RE: STRATHFIELD COUNCIL SUBMISSION TO WESTCONNEX M4 WIDENING ENVIRONMENTAL IMPACT STATEMENT PUBLIC EXHIBITION

WESTCONNEX STAGE 1(A) M4 WIDENING (SSI-6148)

Figure 8.2 Parramatta Road and M4 Motorway traffic - Base 'do minimum' and M4 Widening scenarios (2021)

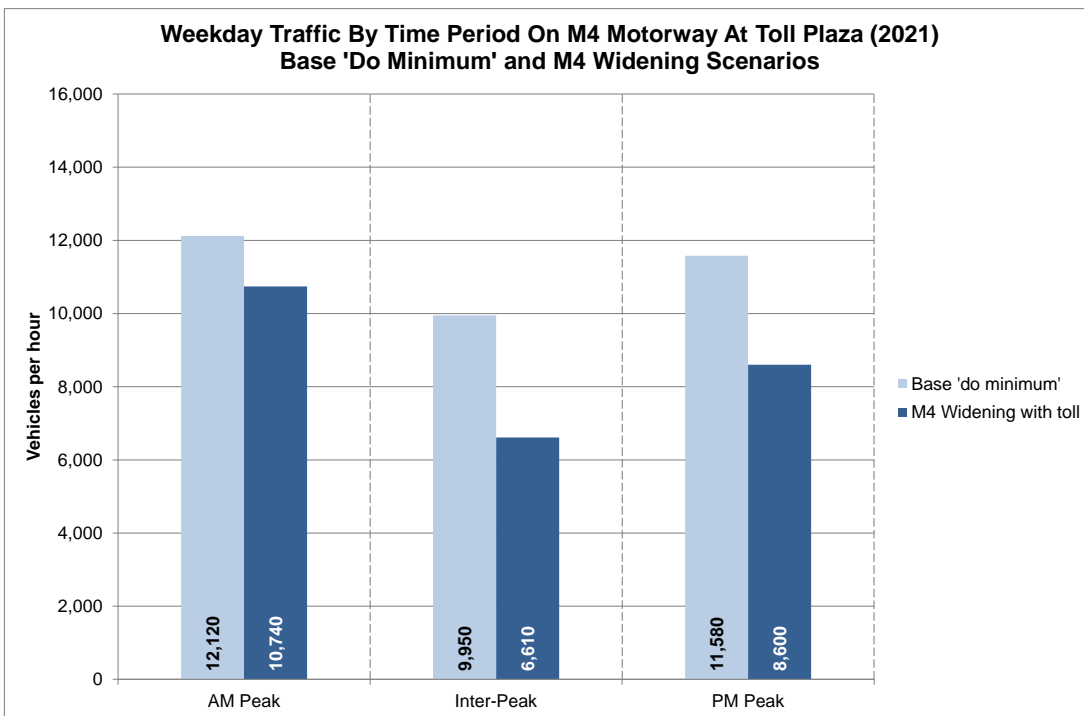
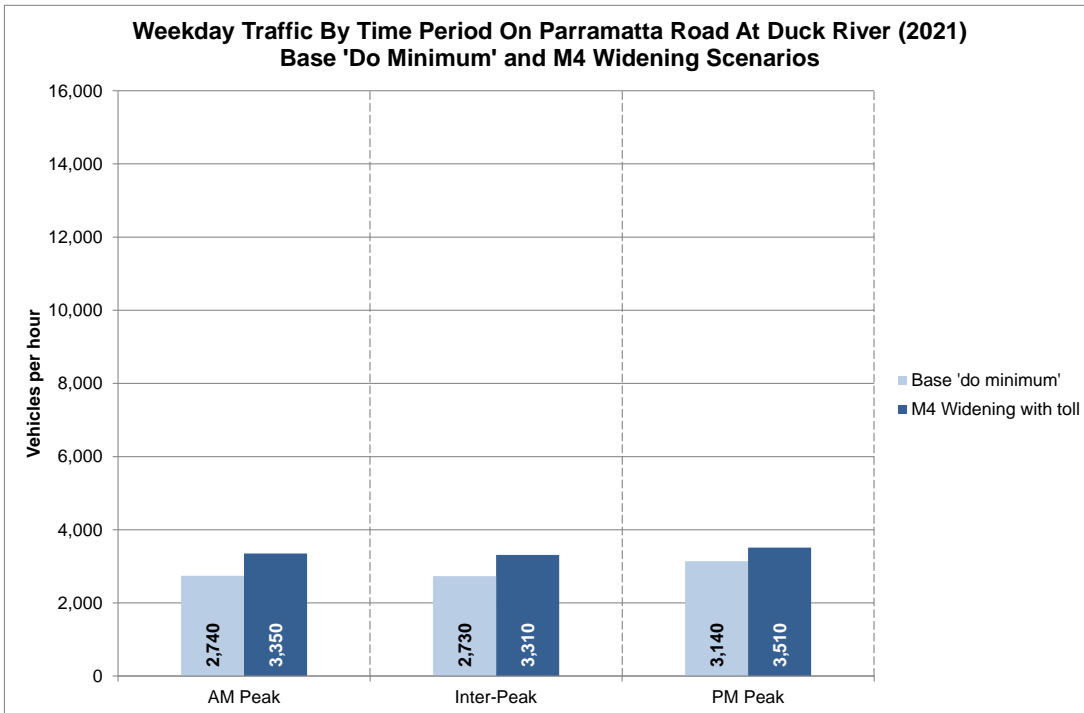
Council raises its concern on the projected impact of the M4 Widening to the Parramatta Road traffic volumes in the Homebush/ Strathfield precinct. As indicated in the assessment of Transport and Traffic Issues on Part 8.1 of the EIS, the traffic modelling generally shows minimal to no improvement on the Parramatta Road traffic volumes in the Homebush/Strathfield precinct, particularly in the Parramatta Road/Concord Road/Leicester Avenue and Parramatta Road/Wentworth Road intersections even after the full WestConnex project is completed.

Figure 8.5 Comparison of hourly weekday traffic volume changes on Parramatta Road

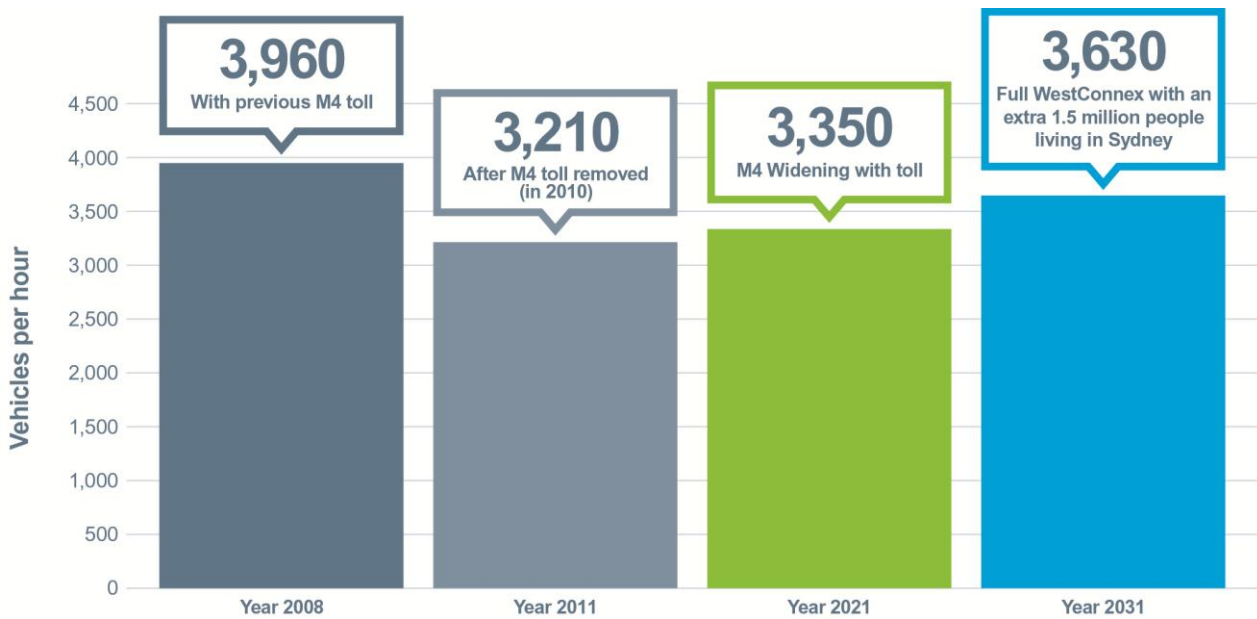
The reintroduction of the toll system appears to serve as a disincentive and have the effect of limiting the patronage of the M4. According to the *WestConnex M4 Widening Traffic and Transport Working Paper 4* (2014) prepared by the WestConnex Delivery Authority, it is estimated that volumes on the M4 would drop and Parramatta Road volumes would increase despite the increased capacity on the M4 Motorway. The report also highlights that the total traffic volumes increased by 23 per cent after the removal of the tolls in 2010.

Council suggests that further analysis and consideration be given on the implications of the tolling system on Parramatta Road and local streets. Mitigation measures should also be modelled and considered in order to potentially manage the potential impacts of road users using alternate routes and rat running local streets.
